Re: PA22-019 – Groundhog PRD –*Incomplete*

Your application has been determined to be ***incomplete*** as of the date of this letter. Please provide the following items, as they are necessary to determine a complete application for processing:

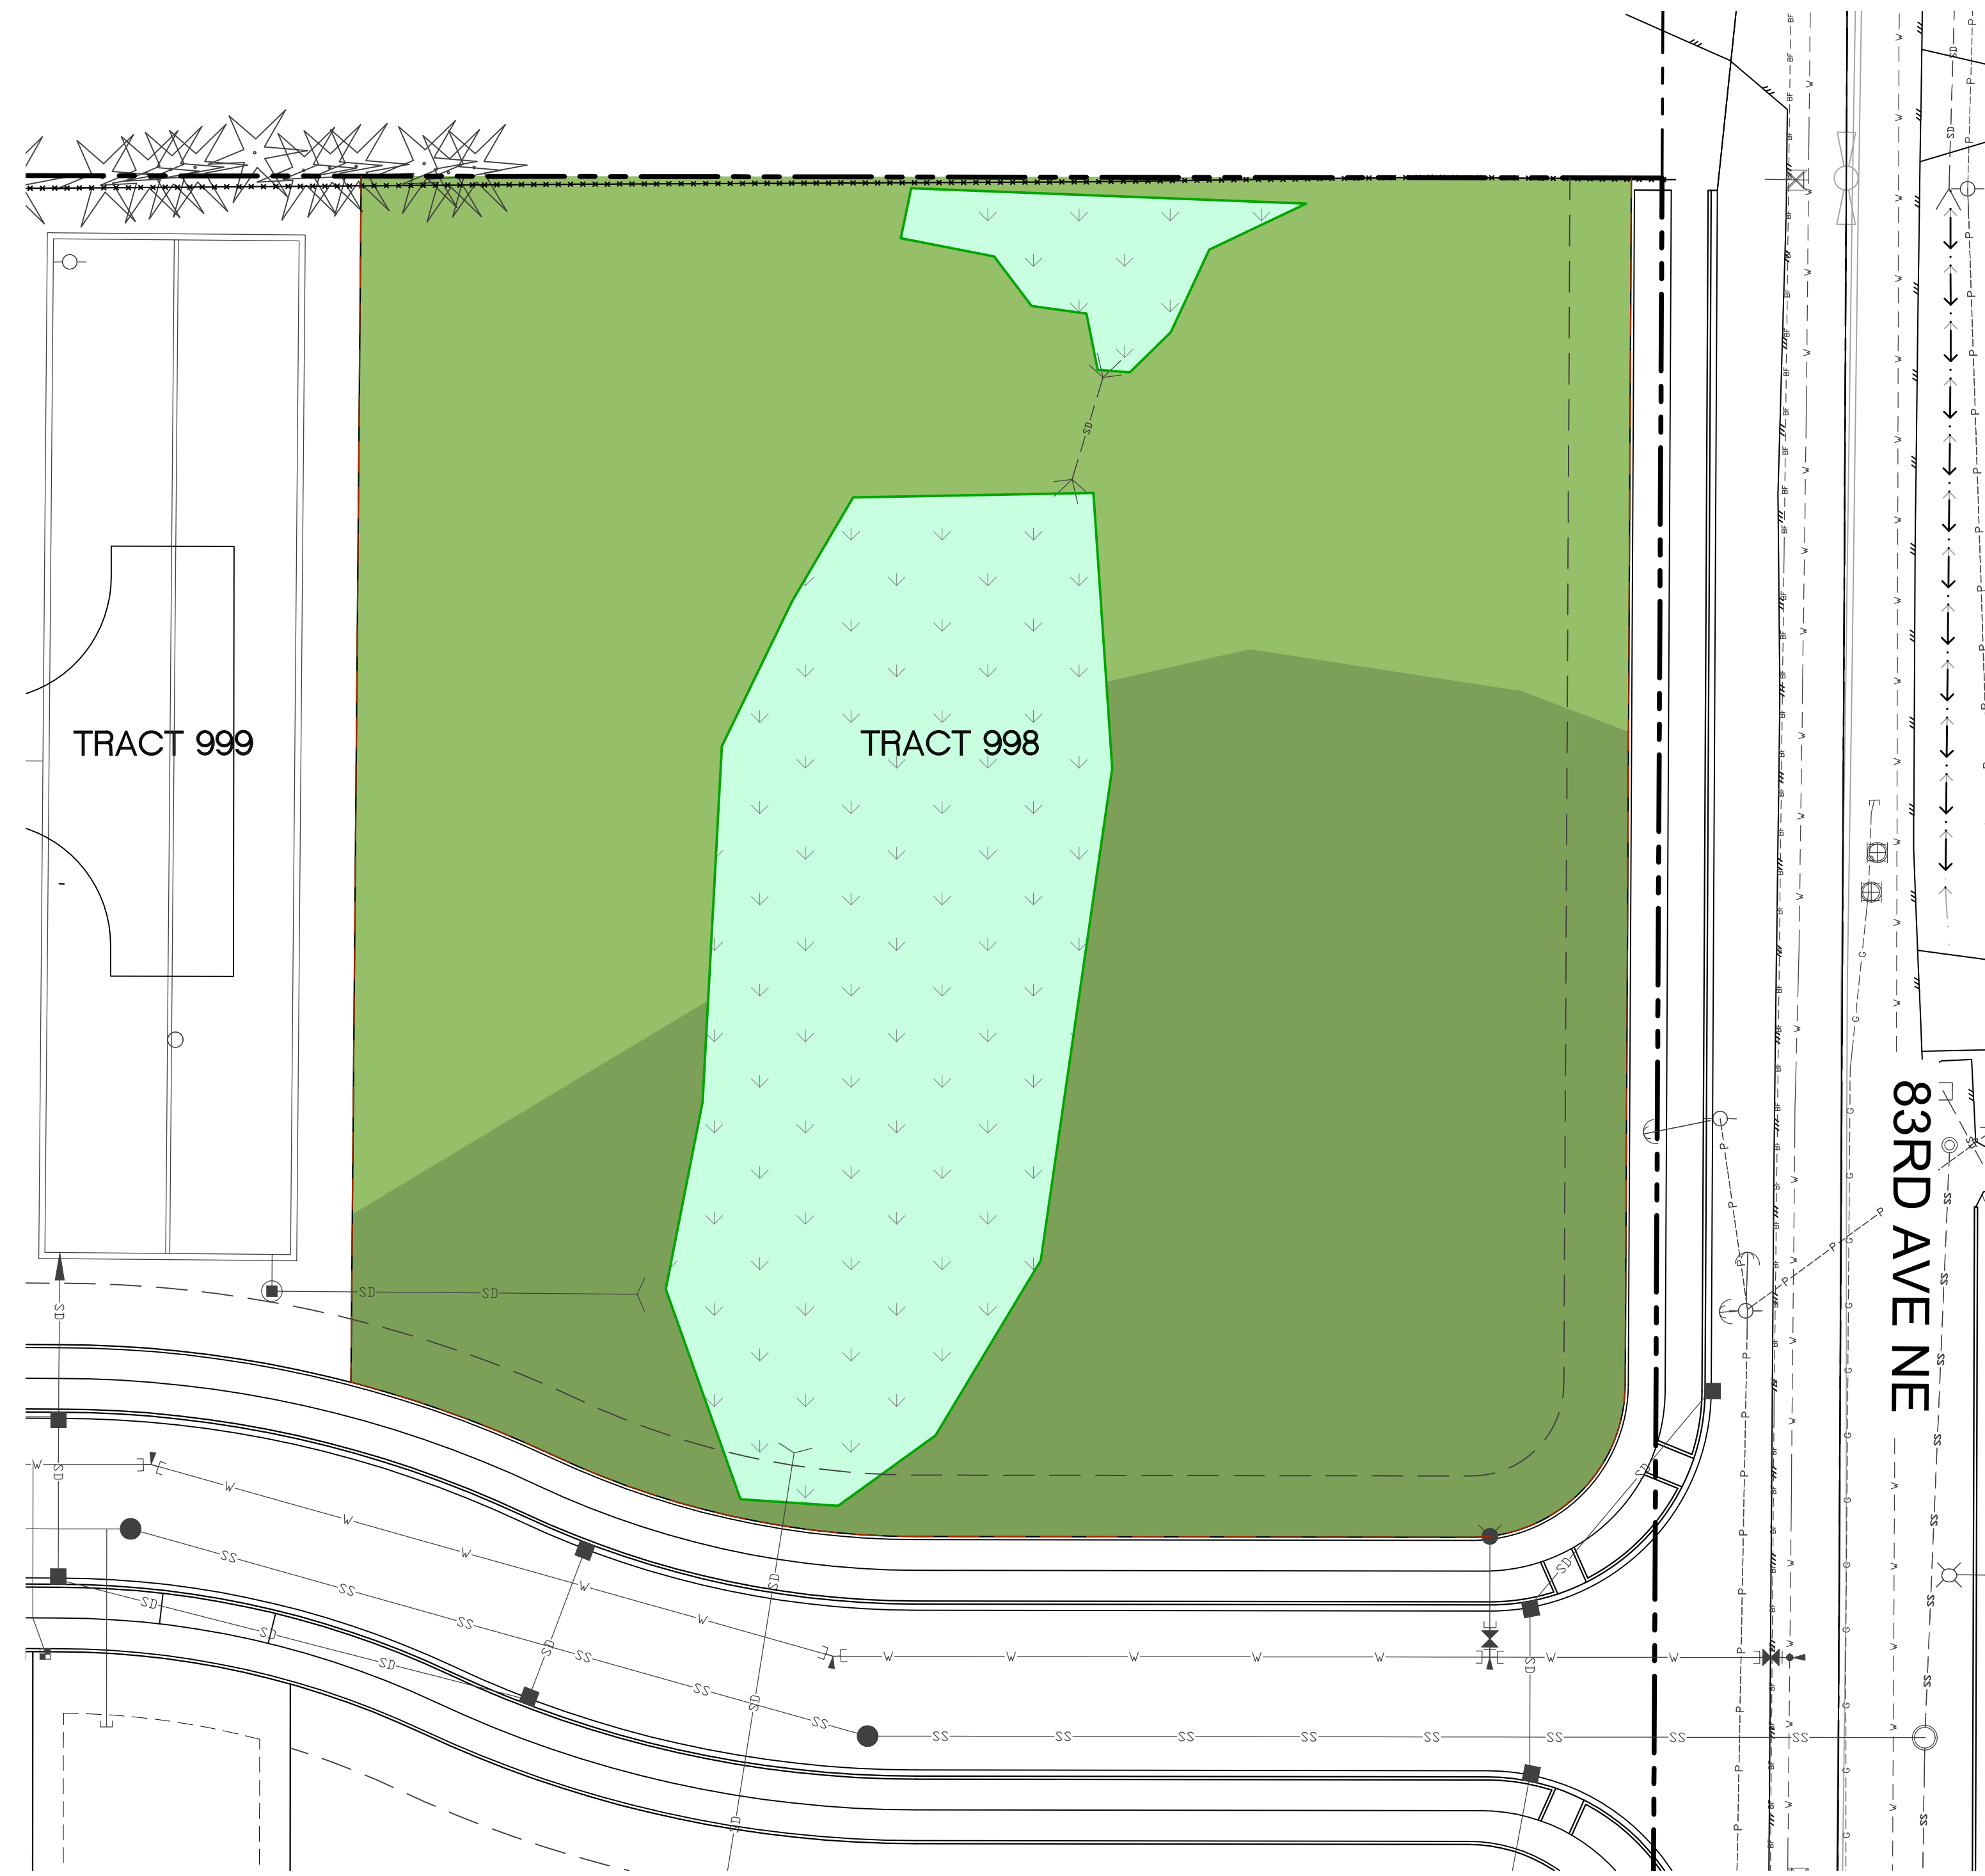
- a. It appears permanent buffer impacts are proposed for Wetlands A & D. It is unclear if off-site Wetland E buffer extends onto the proposed development site. Pursuant to MMC 22E.010.100(5) buffer widths may be averaged or reduced, no more than 25 percent, subject to the buffer averaging and reduction sequencing criteria. If a buffer reduction greater than 25% is proposed a variance would be required to be approved by the Hearing Examiner in accordance with MMC 22E.010.100(13).

- b. Demonstrate mitigation sequencing per MMC 22E.010.110 for the proposed critical areas impacts have been addressed. Specifically, it appears the applicant is proposing to fill Wetland B. In addition to demonstrating compliance with MMC 22E.010.110, the applicant is required to obtain approval from the US Army Corps of Engineering and Washington State Department of Ecology in order to fill Wetland B. The JARPA application will need to be submitted concurrently with the land use application.

- c. Based on the scope of development, impacts to the wetlands are anticipated, including grading activity within the required buffers. A preliminary wetland mitigation and enhancement plan is required to be prepared in accordance with MMC 22E.010.120 through MMC 22E.010.160.
